Online Comment

Application H08-0218-20
Location Site Adj. Silverdene Boston Road Gosberton PE11 4NR
Proposal Residential Development of 18 Dwellings - outline approval H08-0866-18

Name Angela Doherty
Address Housing Strategy

Date Submitted 17-06-20
For/Against Comments

Drawing Number:	Rev:
A1435 - 18	A

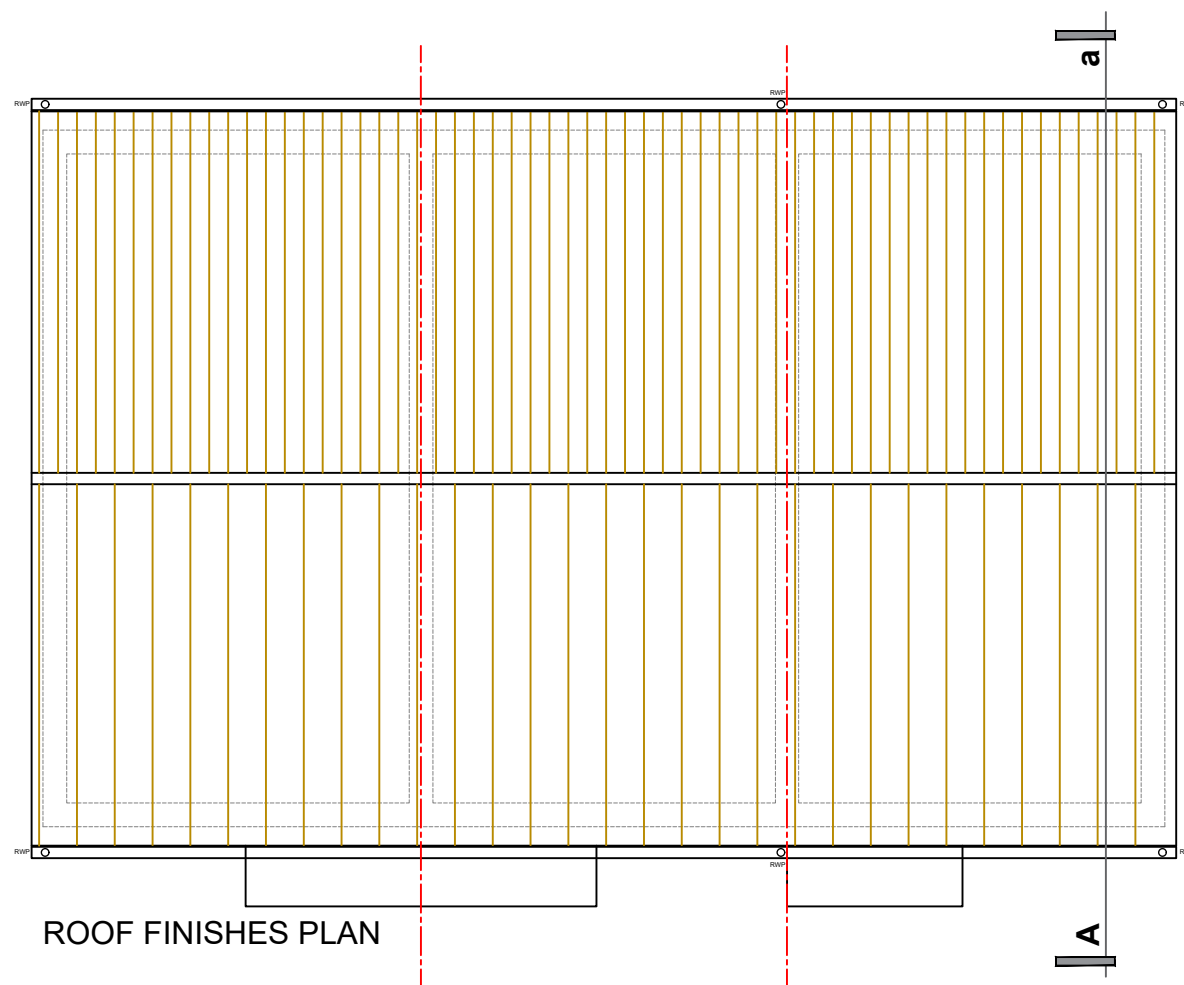
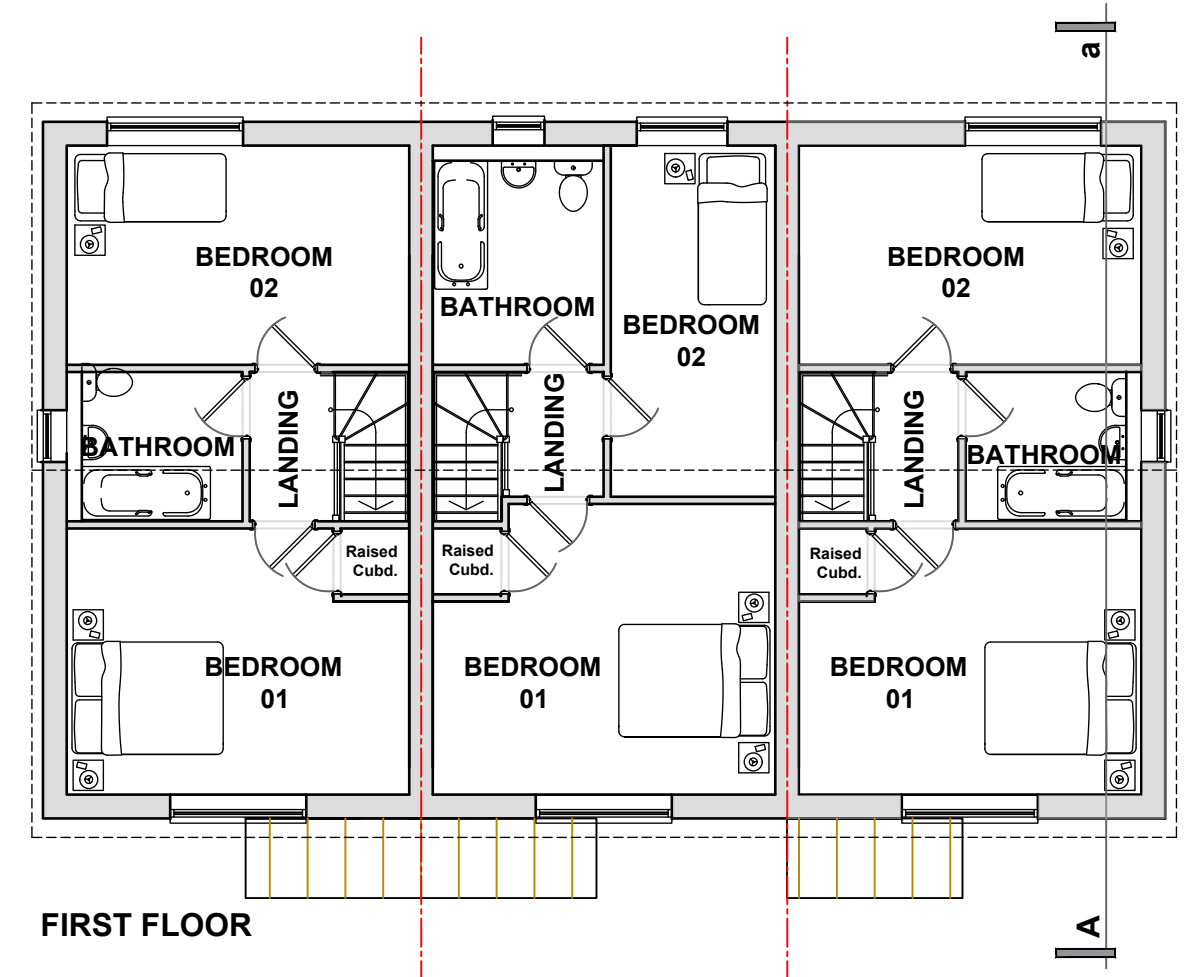
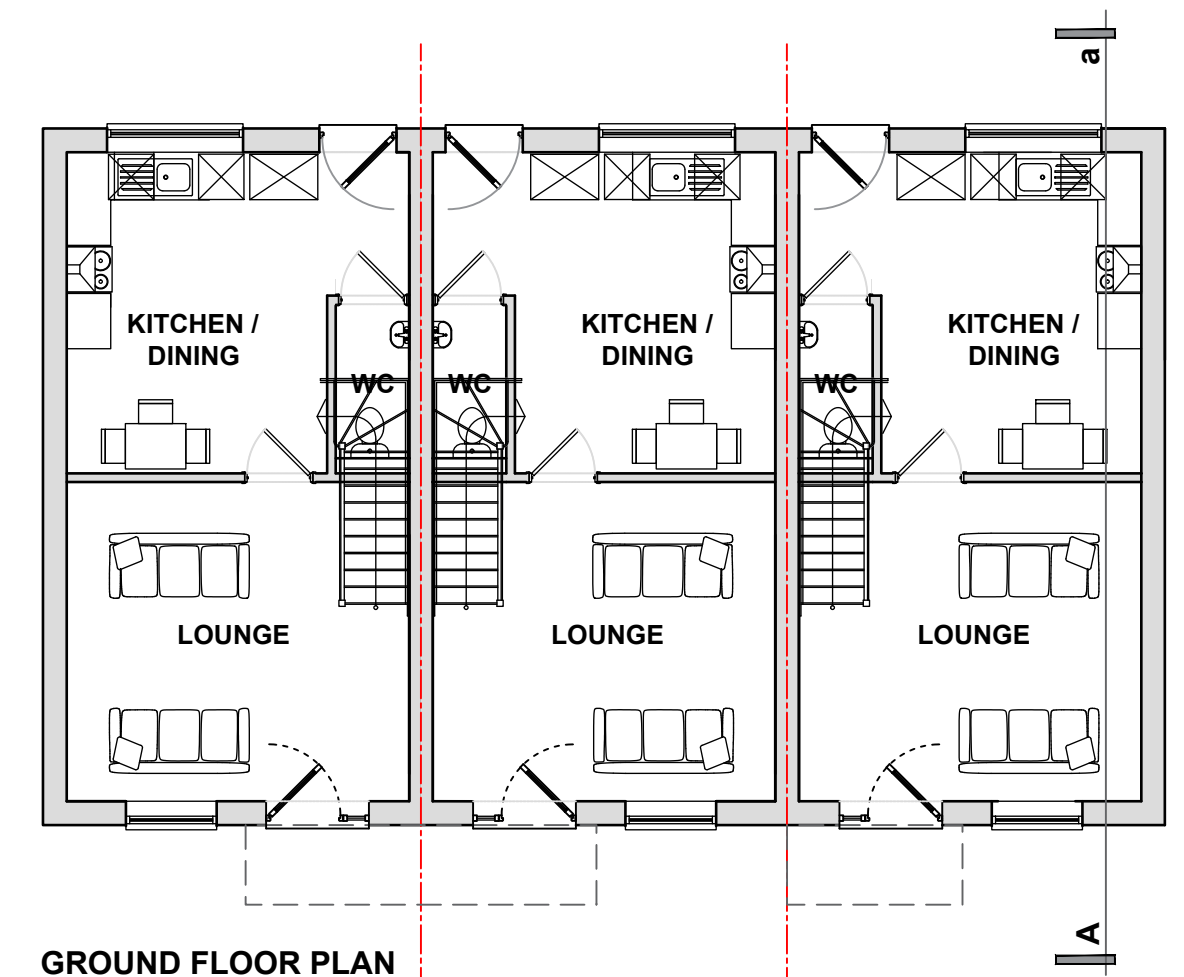
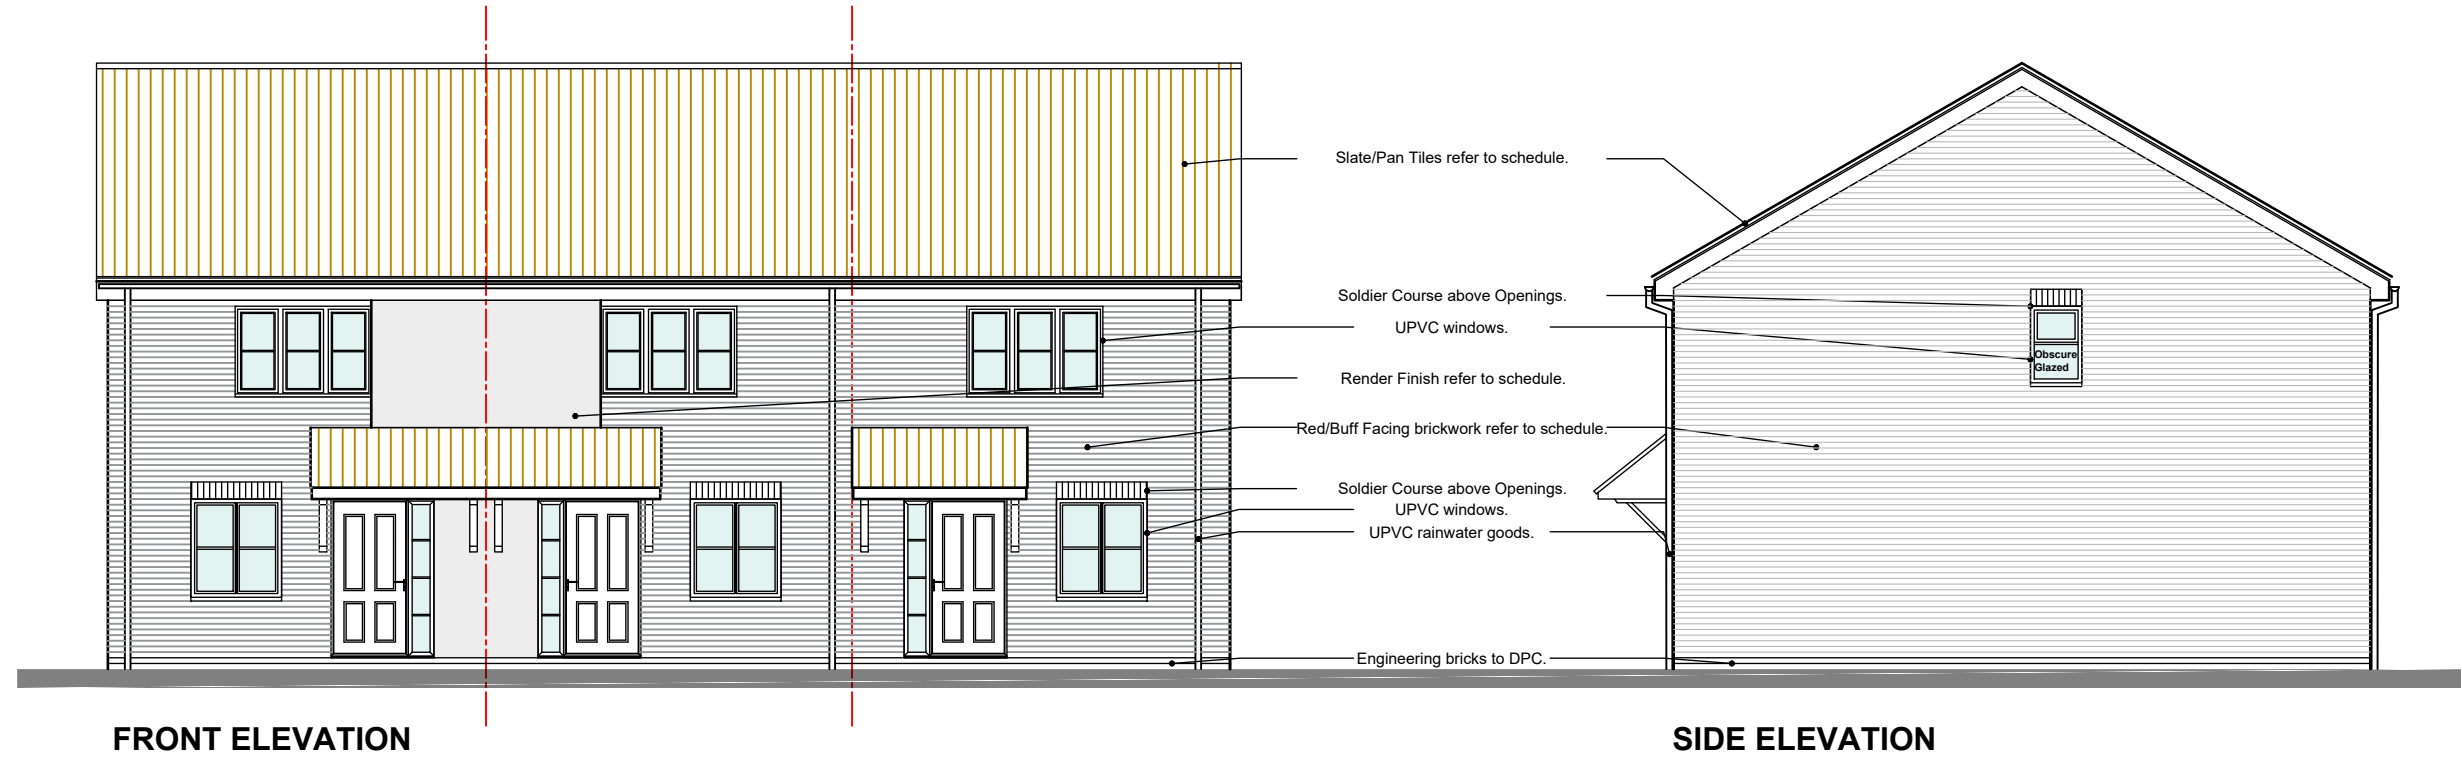
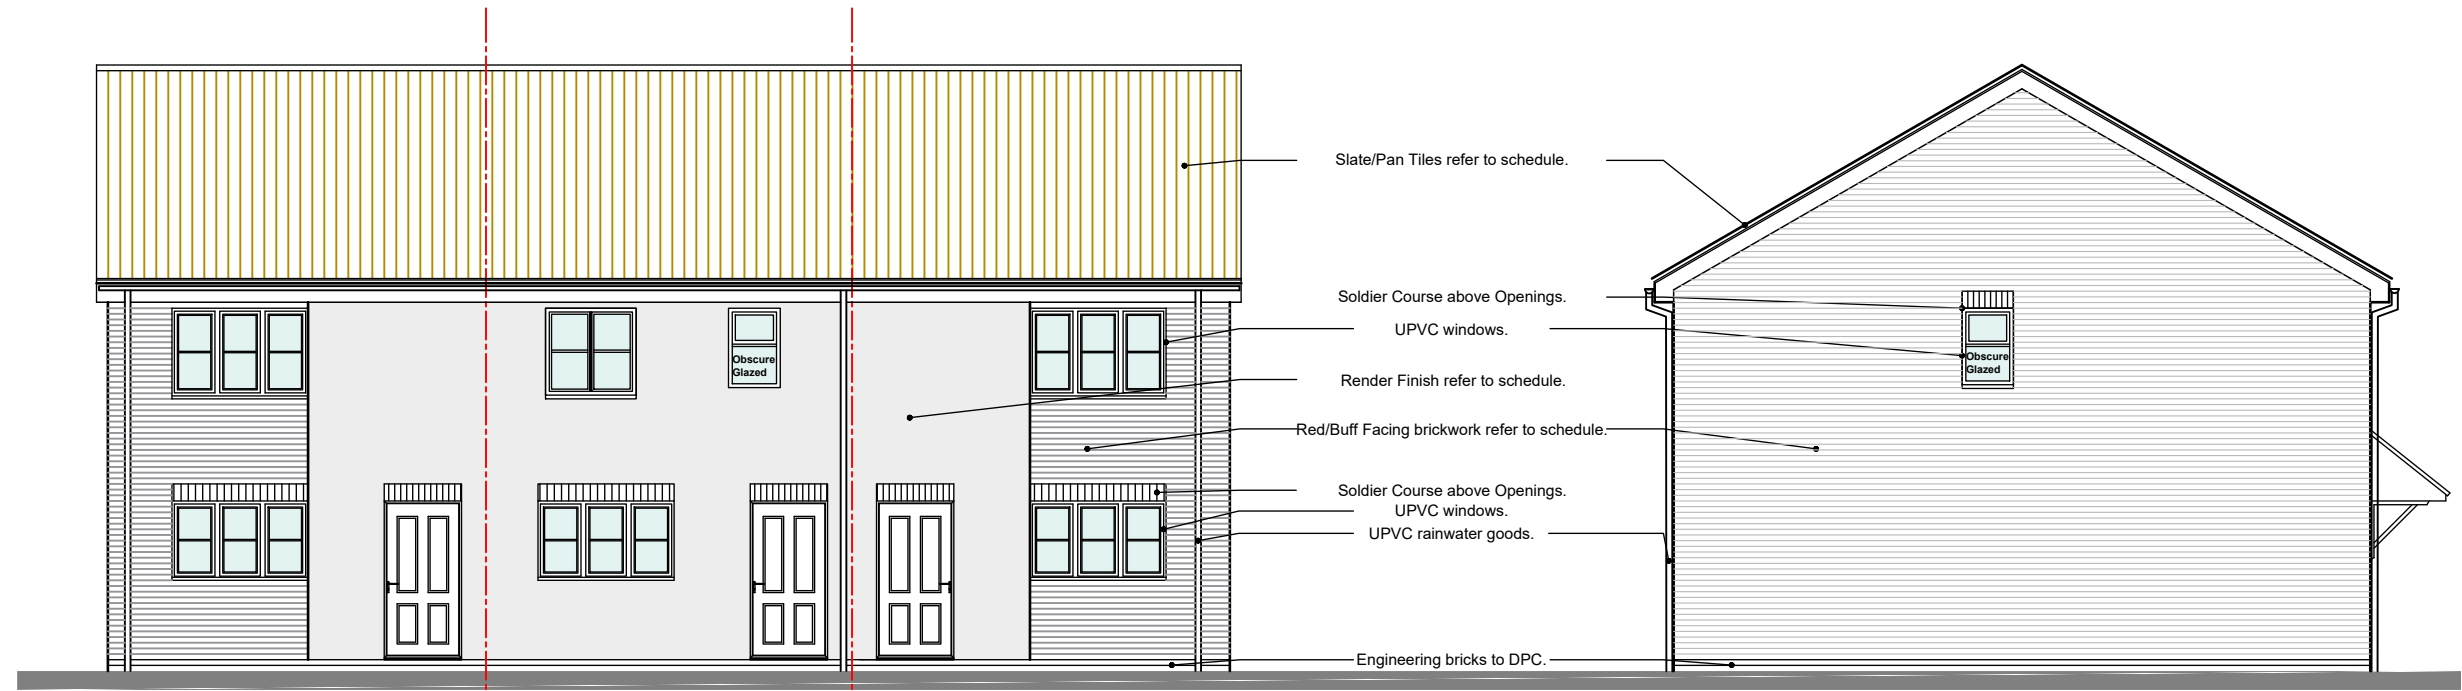
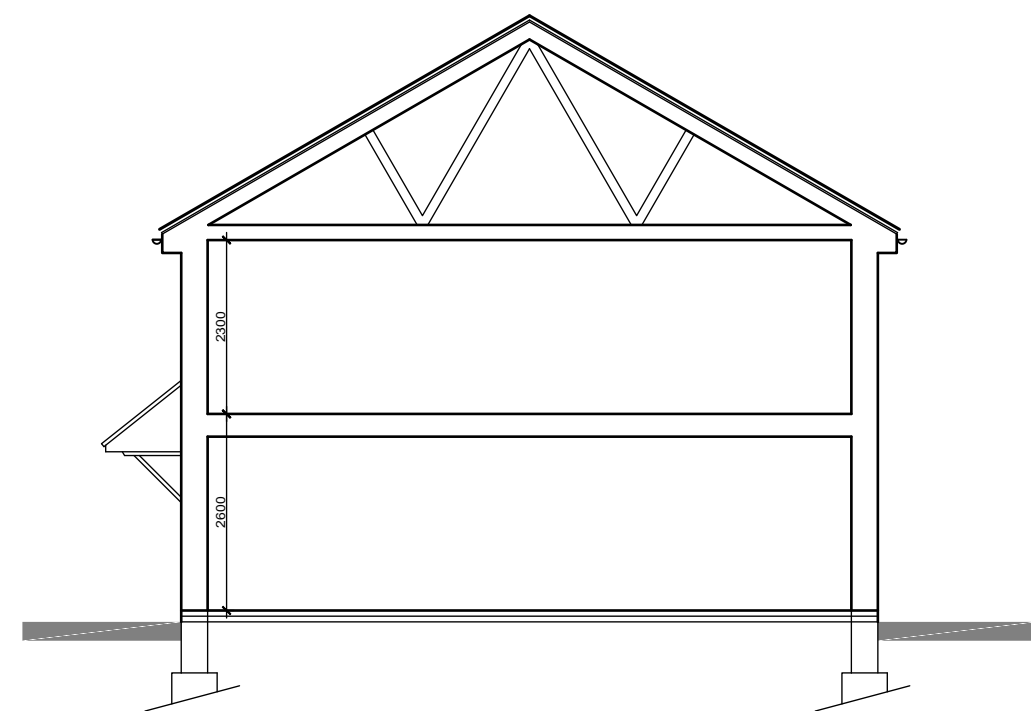
Detailed within the Affordable Housing submission for this application, the developer is proposing to deliver 5 affordable homes, with 3 x 2 bedroom houses for Affordable Rent and 2 x 2 bed houses for Intermediate Housing for Sale. The percentage of affordable housing proposed and the tenure split proposed broadly accords with Policies 18 of the South East Lincolnshire Local Plan. However, Policy 17 encourages a range of house types and sizes to meet a range of needs. To accord more closely with this Policy the developer should reconsider amending the Affordable Rented mix to deliver 2 x 1 bed houses and 1 x 2 bed house.

It is unclear the internal floor space of the affordable homes. As per the wording within the South East Lincolnshire Local Plan it would be preferable for the homes to be built to the 'Nationally Described Space Standards'. Ideally the affordable housing should be spread proportionately across the scheme to enable a mixed and sustainable community.
